Your ref:	Instillation of CAT ladder to...	Please reply to:	Central Planning Team
Our ref:	21/07191/FULL	Tel No:	2514
		Fee Queries:	0207 641 6500;
		Email:	planningreception@westminster.gov.uk;
Mr Chris Moore McBains 26 Finsbury Square London EC1A 2DS		Incomplete Applications Development Planning City of Westminster PO Box 732 Redhill, RH1 9FL	
			28 October 2021

Address: 5 Bryanston Place, London, W1H 2DG

Proposal: Installation of external Cat ladder at first floor level to provide access to the roof for maintenance.

Drawing Title
5 BRYANSTON PLACE
EXISTING ELEVATION TO BRYANSTON PLACE

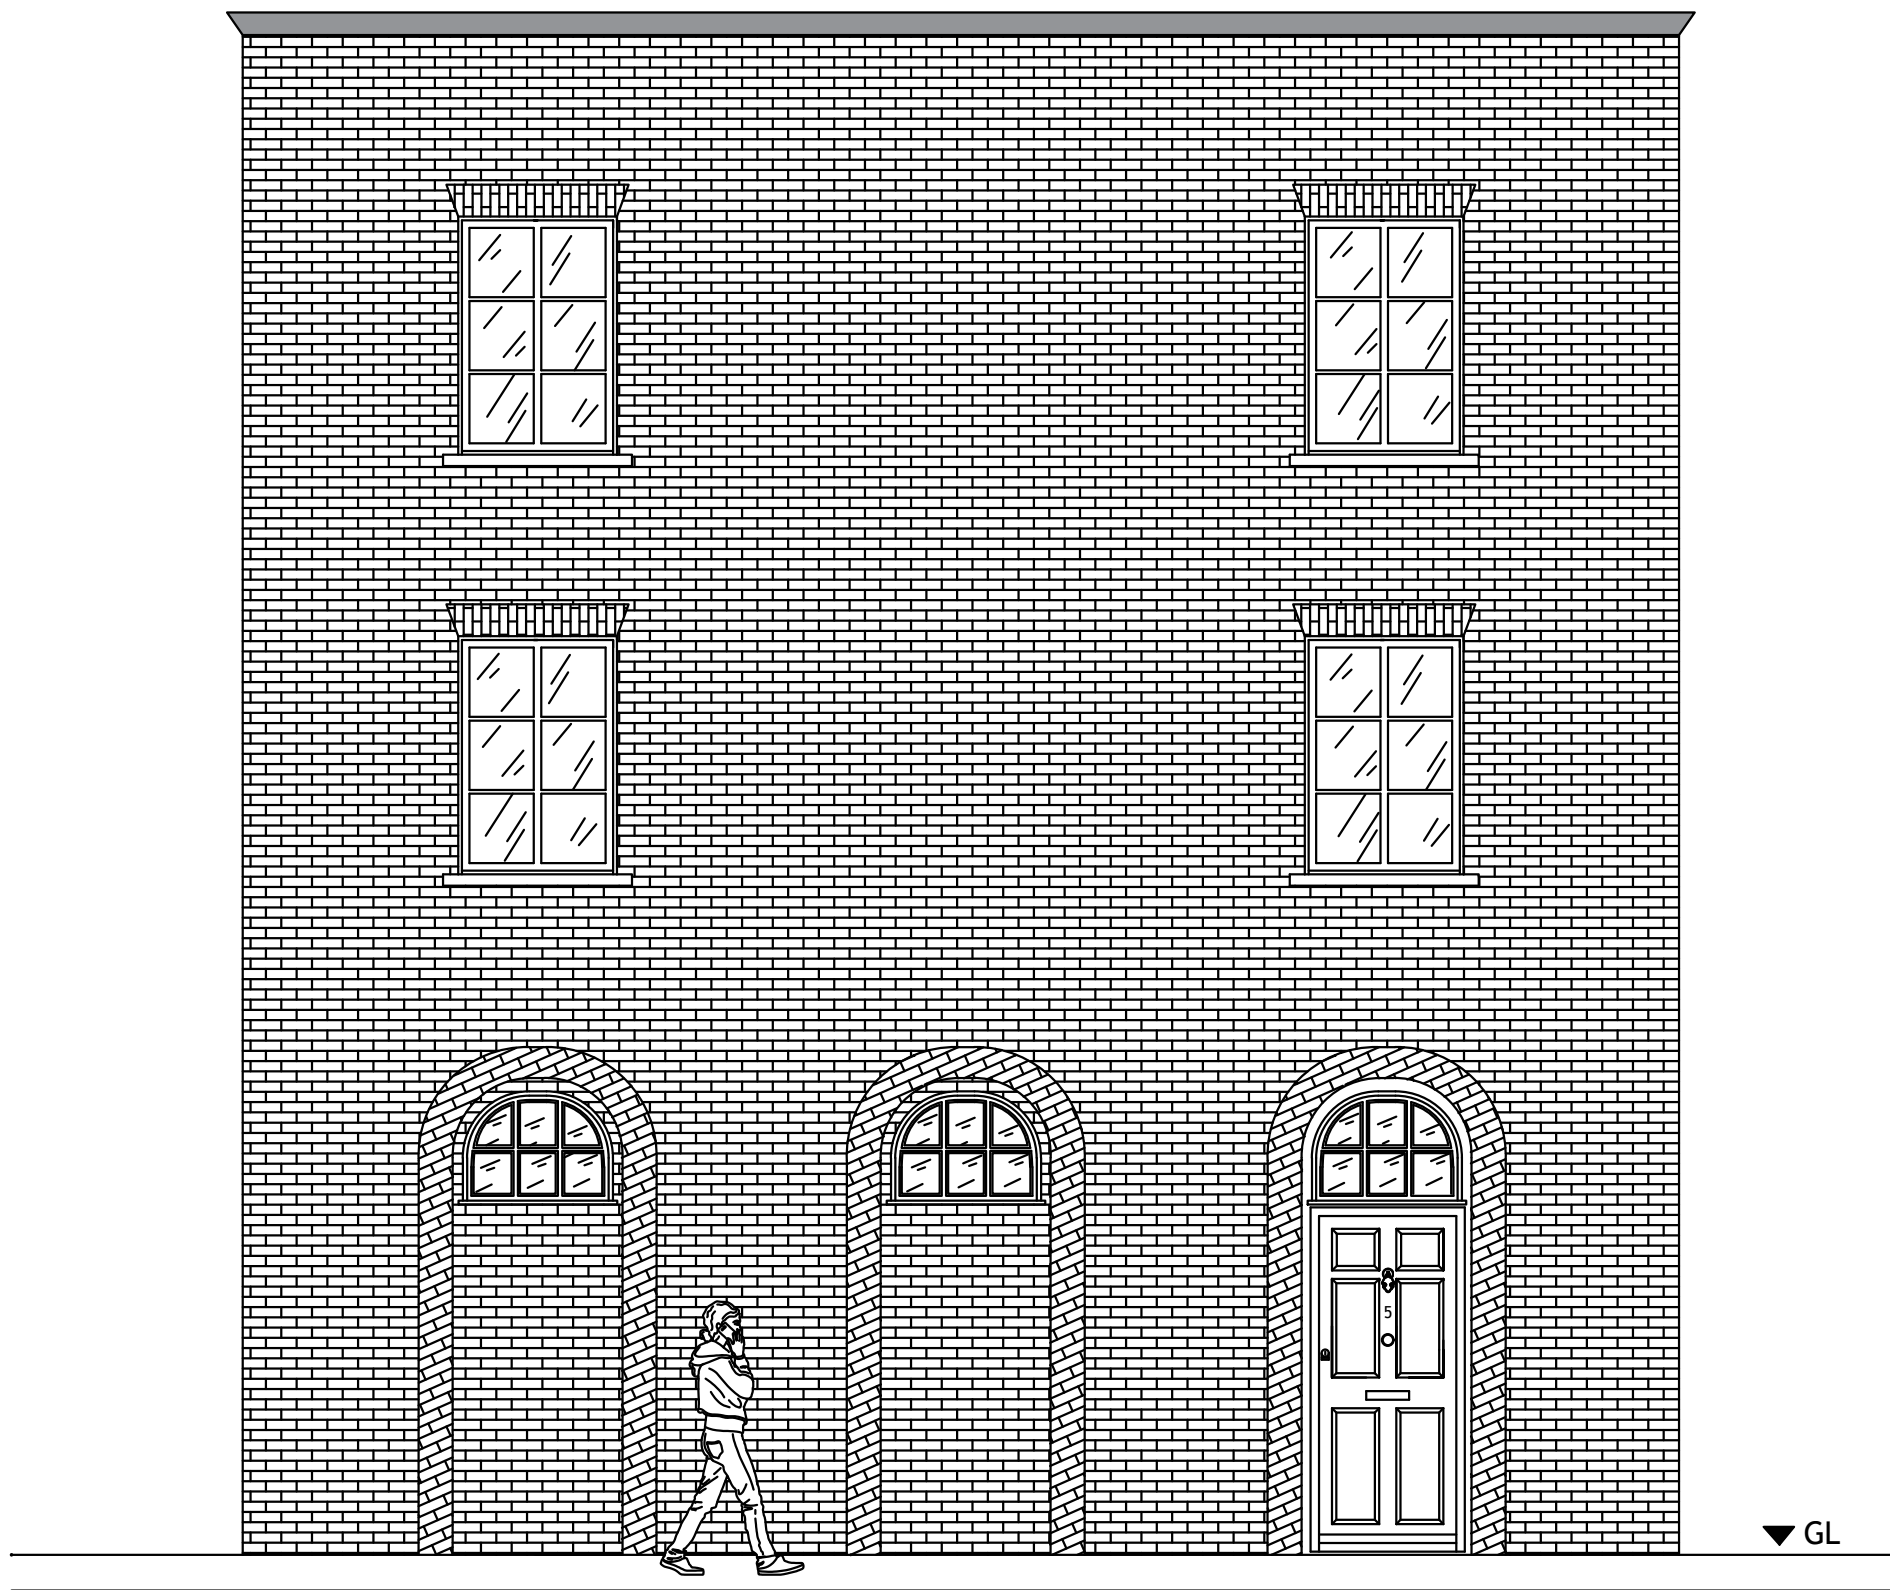
- Existing front and side elevations with correct labelling including a scale bar.
- The proposed elevations you have provided do not have scale bars. Please revise your drawings to include scale bars.
